TANKERSLEY PARISH COUNCIL

Planning Application - 2026/0420 - Erection of 10no. 2 and 3 storey detached dwellings

The Parish Council objects to the development.

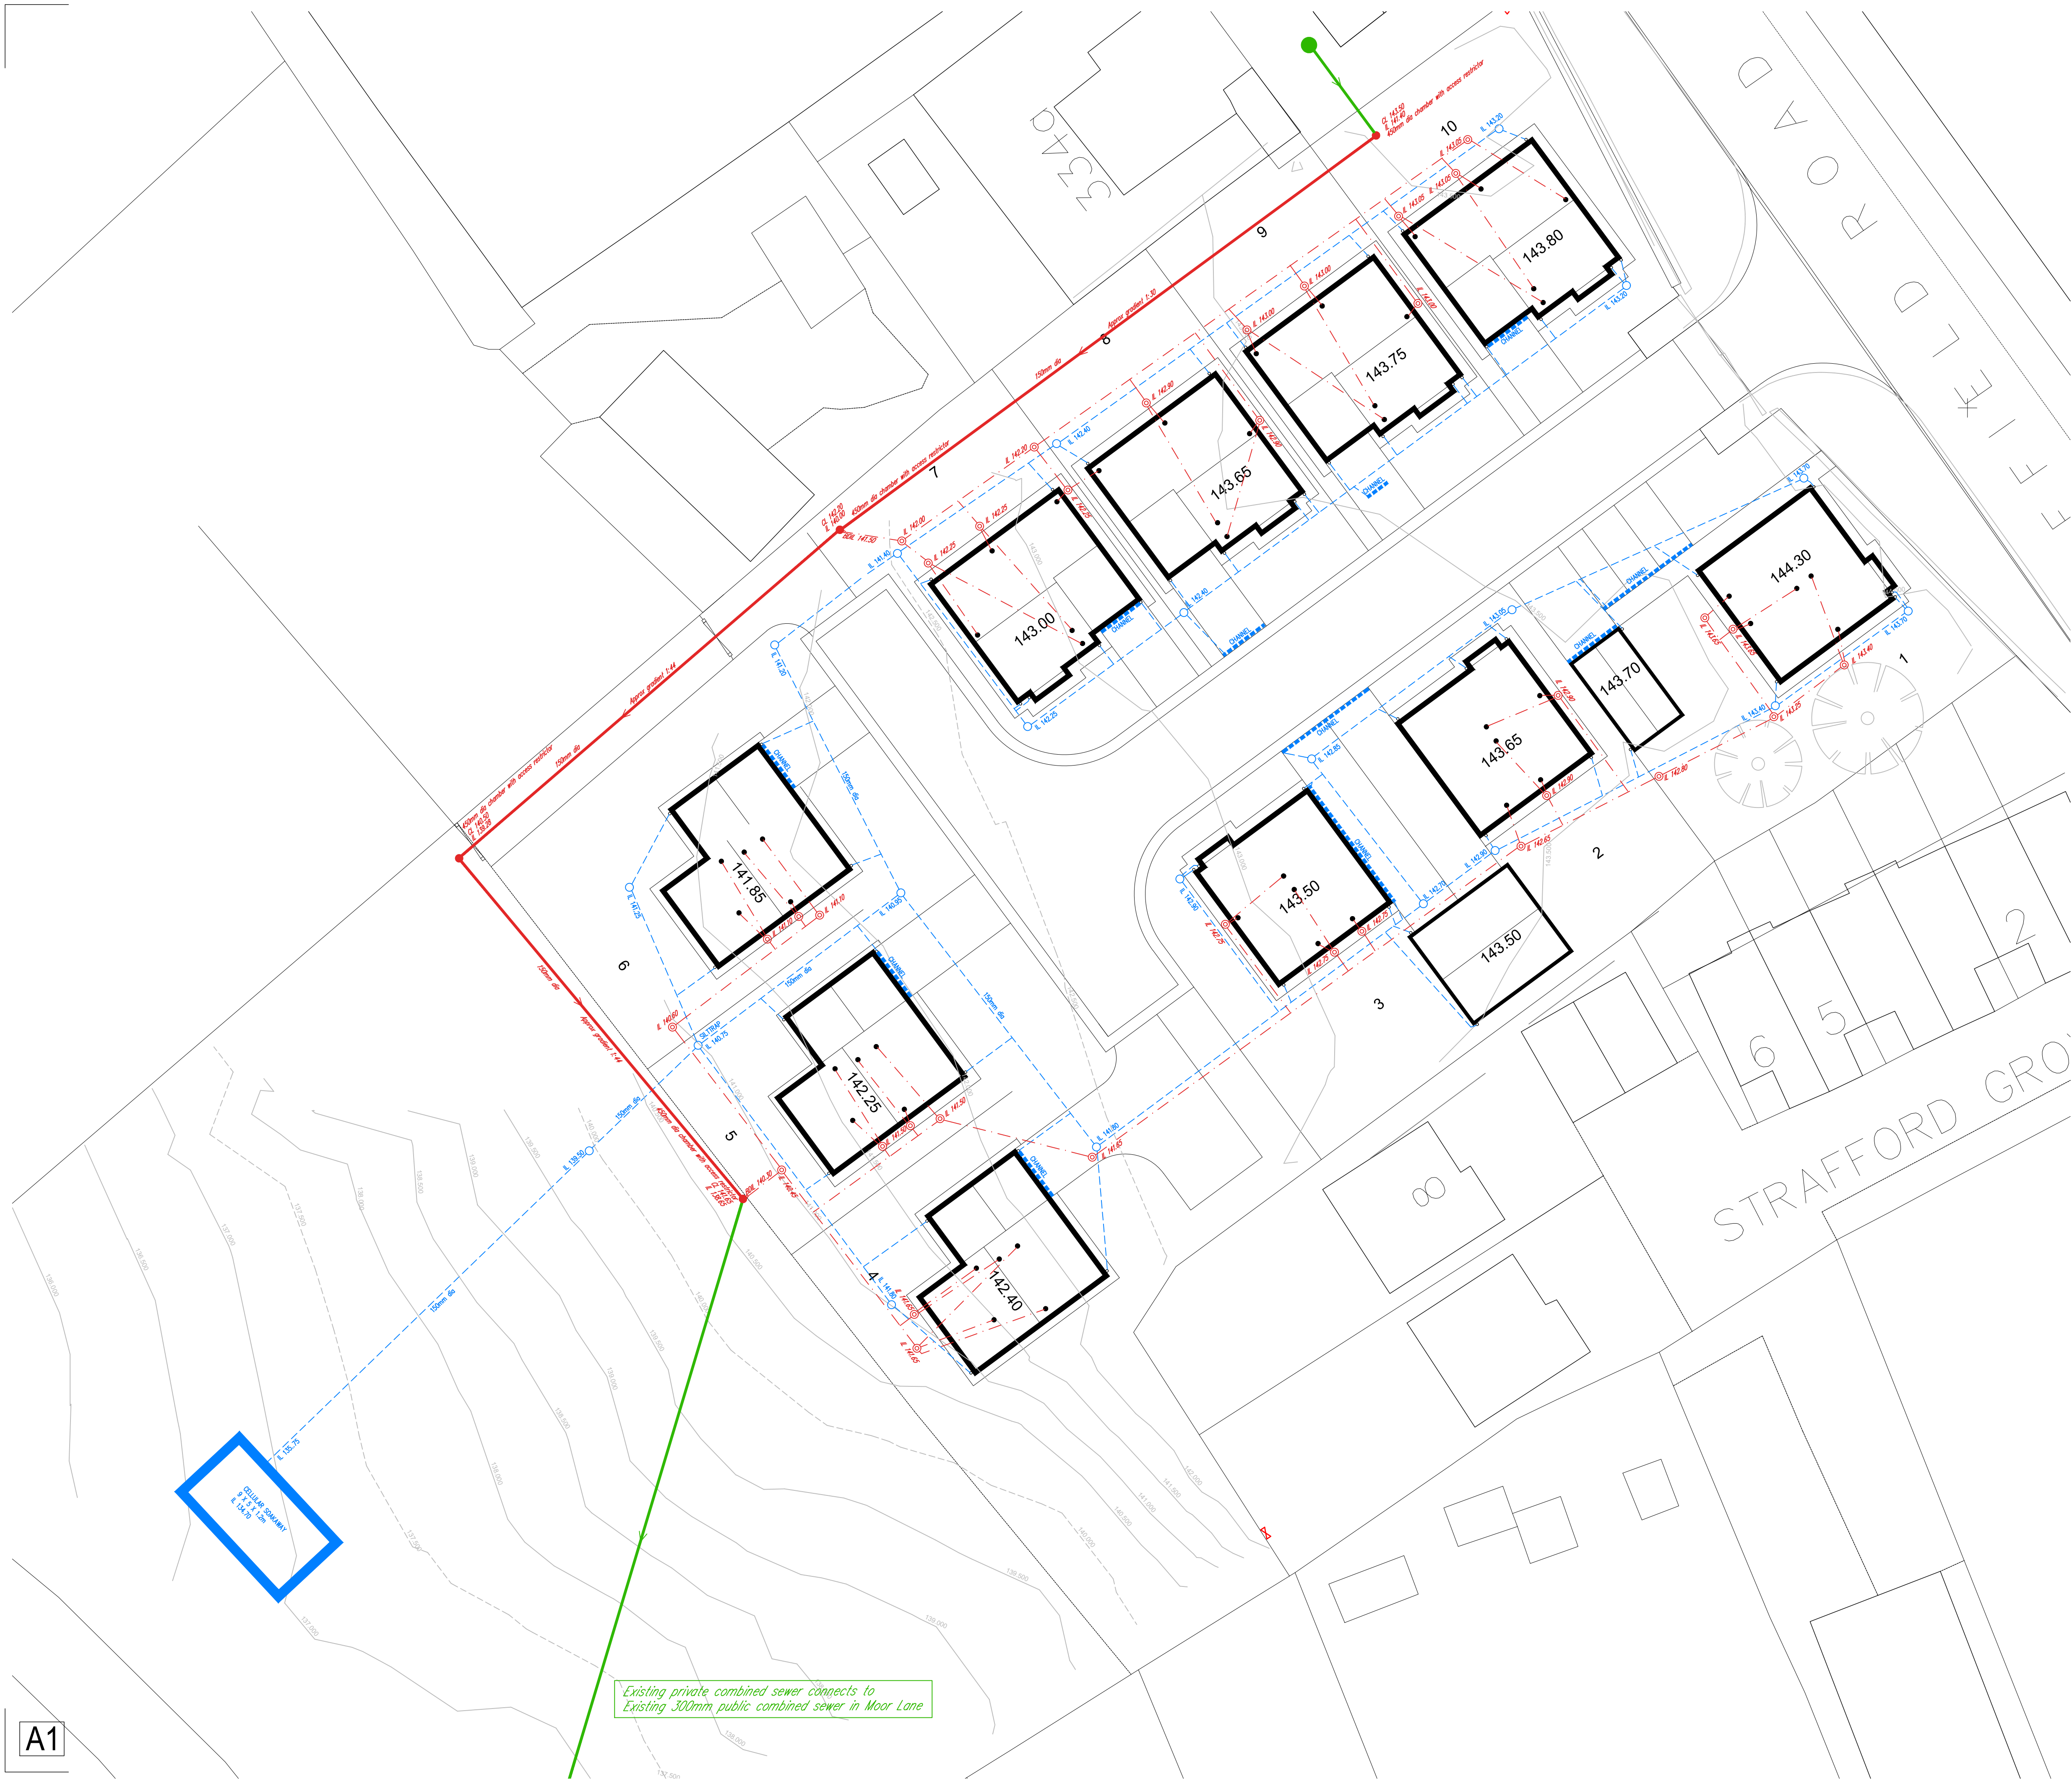
1. The Parish Council has concerns regarding existing drainage and sewer capacity in the area, including reports of sewage backing up or overflowing.
2. The addition of ten dwellings could place further demands upon existing infrastructure.
3. The Parish Council is aware that the drainage report contains the information that a new soakaway is to be installed but questions whether this will be enough to support the already overloaded drainage system that has been the source of complaints for some time.
4. The Parish Council requests that Yorkshire Water and Barnsley Council's drainage specialists are consulted and that the capacity of the existing foul and surface-water drainage systems is properly assessed.
